From: [REDACTED]
Sent: 23 June 2026 16:49
To: Susan Haley
Subject: RE: A/80/26/CLP - 56 Arundel Road, Angmering
Attachments: FRESH Architects-Arundel Road.pdf

[REDACTED]
Subject: A/80/26/CLP - 56 Arundel Road, Angmering

I have begun reviewing application A/80/26/CLP - 56 Arundel Road, Angmering and have noticed that the northern side wall of the rear extension extends ever so slightly beyond the rear elevation (see blue highlighted area).

Proposed Ground Floor Plan

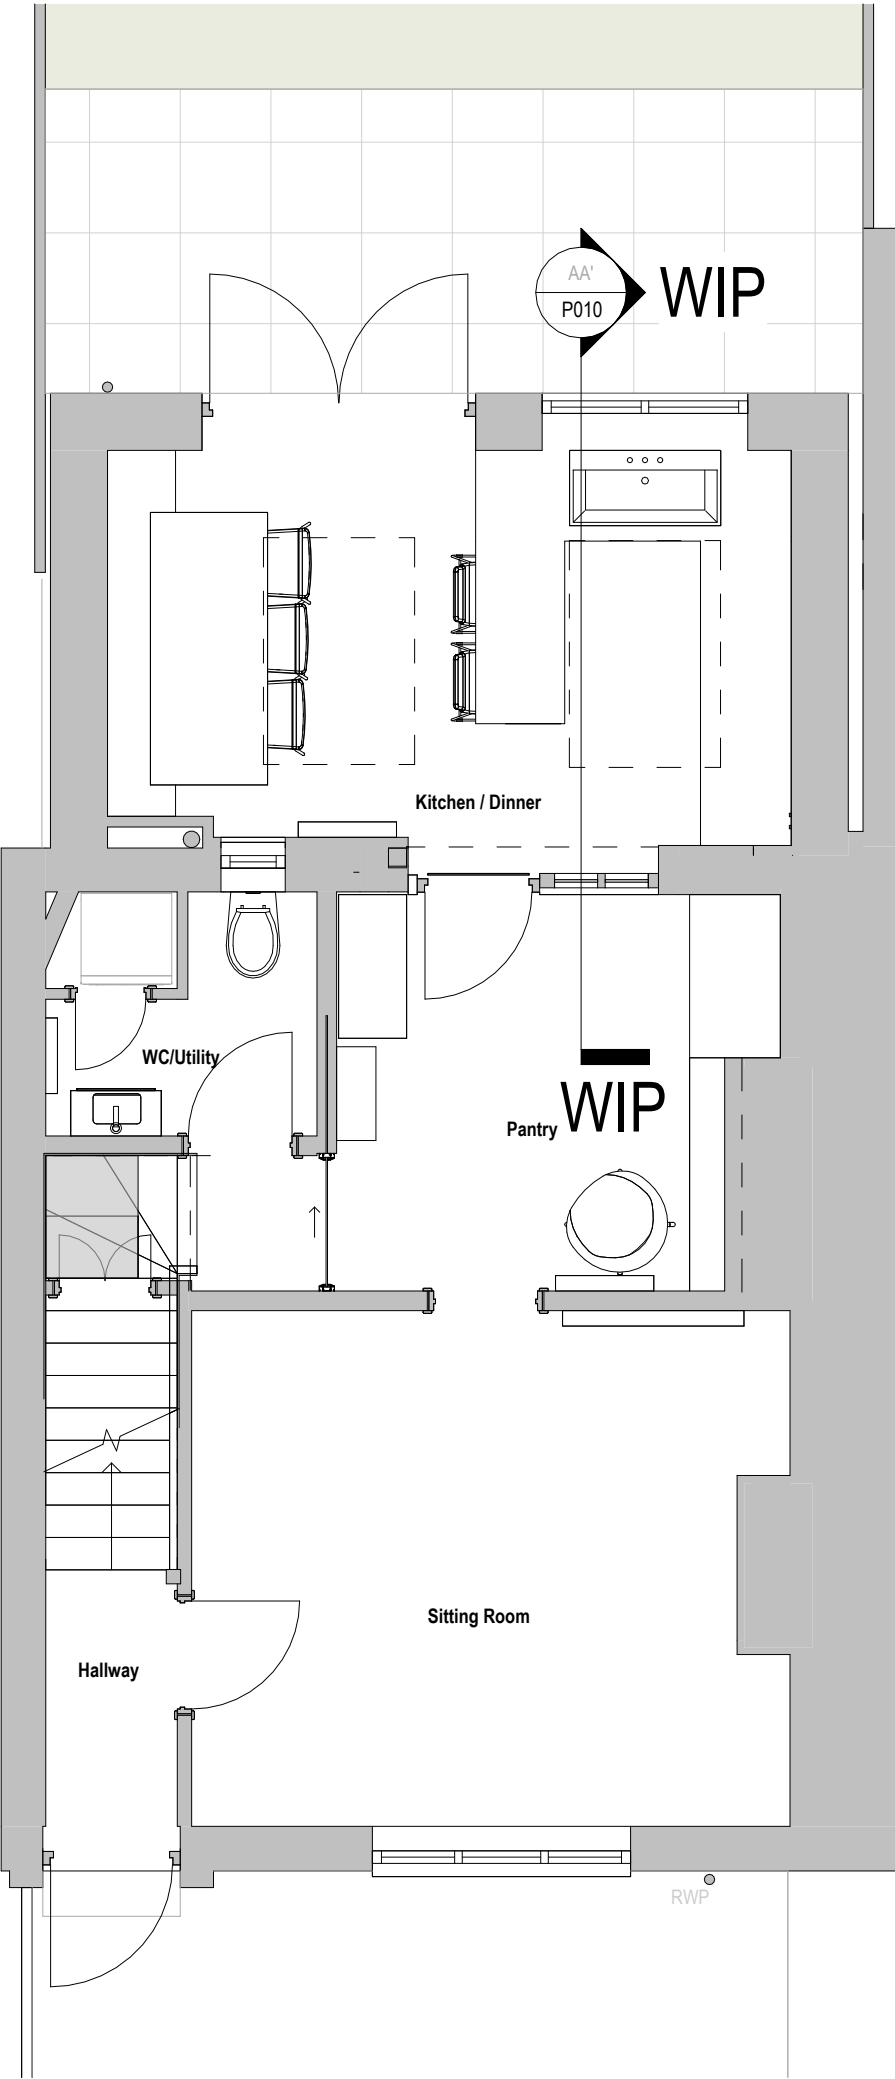
Under Schedule 2, Part 1, Class A (1 (e)(ii) (The Town and Country Planning (General Permitted Development) (England) Order 2015), the proposal is not permitted development, as per the wording of the Act below.

Therefore, the proposed rear extension must be in line with the rear wall and not extend beyond it.

This is a terraced house, apologies about this, please find attached revised plans indicating this correctly.
